Re: State Significant Development (SSD 8865 Modification 2) - St Anthony Padua Catholic School

Liverpool City Council was invited to provide comments on the modification request for State Significant Development (SSD 8865 Mod 2) of St Anthony Padua Catholic School at 125-165 Tenth Avenue and 140-170 Eleventh Avenue, Austral. The SSD approval facilitated development of an educational establishment for up to 2,480 students (Kindergarten to Year 12), 200 staff members, a 125-place childcare centre and associated development.

Attachment – Detailed comments

**Figure 6 |** Proposed sign (Source: Applicant’s SRtS 2022)

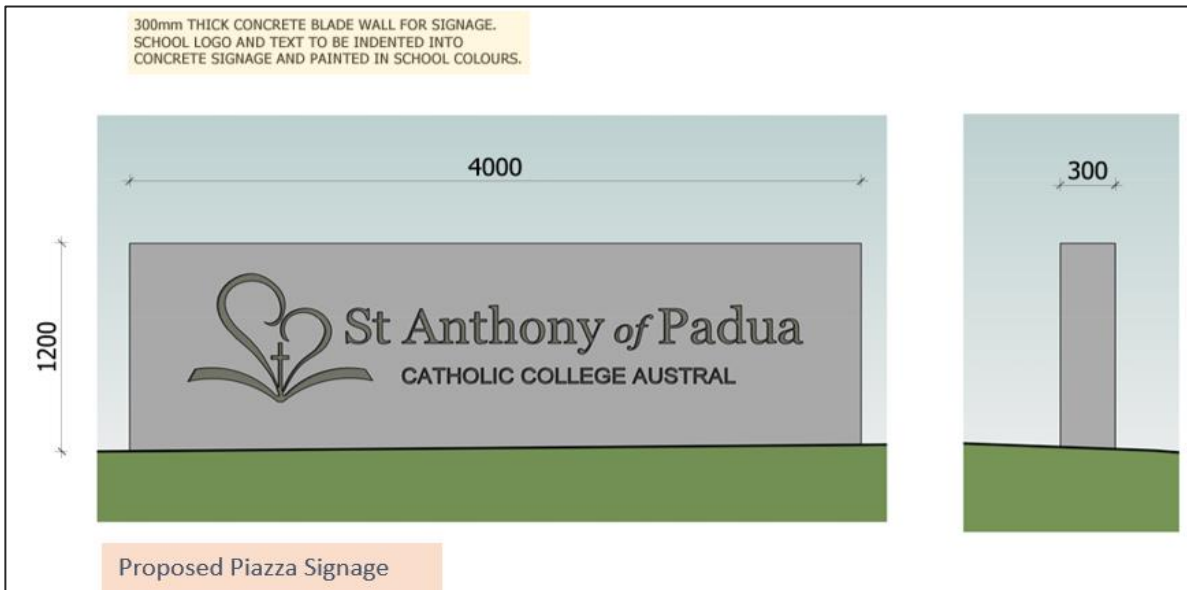
The new external signage to the main school building is supported provided it doesn't conflict with any passive surveillance opportunities between the school and open space (i.e. streetscape and piazza).

**Figure 17** | Proposed materials schedule (Base source: Applicant's SRtS 2022)

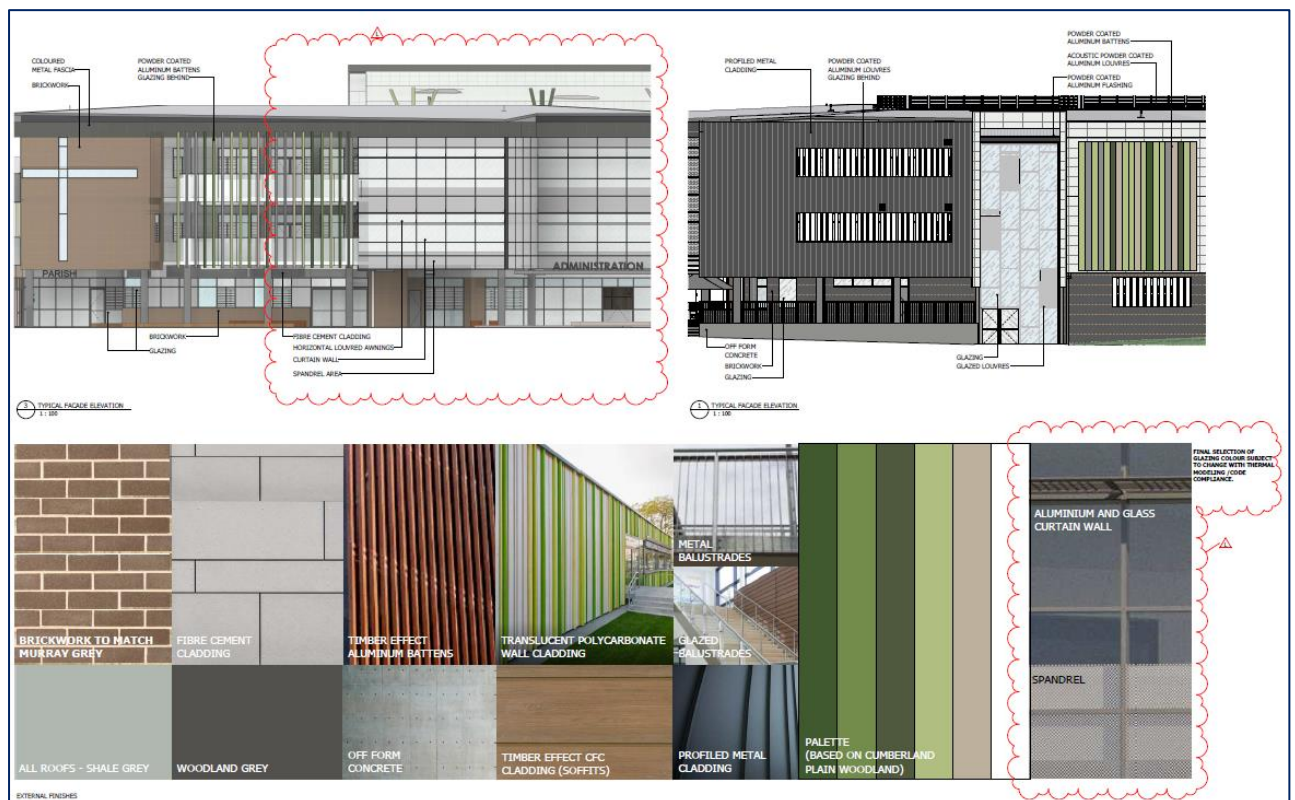
Proposed changes to the northern elevation of the main school building include a new glass curtain wall, horizontal louvred awnings and glazing elements on the façade. Proposed façade treatments must ensure passive surveillance opportunities on to the open space.

1. Better integration is achieved between the stairs and the proposed ramp to the east. The entrances for both the ramp and stairs should terminate at the same or similar locations to ensure equal access for people of all abilities.
2. Proposed changes to the northern elevation of the main school building must adhere to CPTED principles. This is to provide better passive surveillance opportunities onto the open space.
3. The new external signage to the main school building must avoid hindrance to passive surveillance opportunities between the school and the streetscape as well as the piazza.
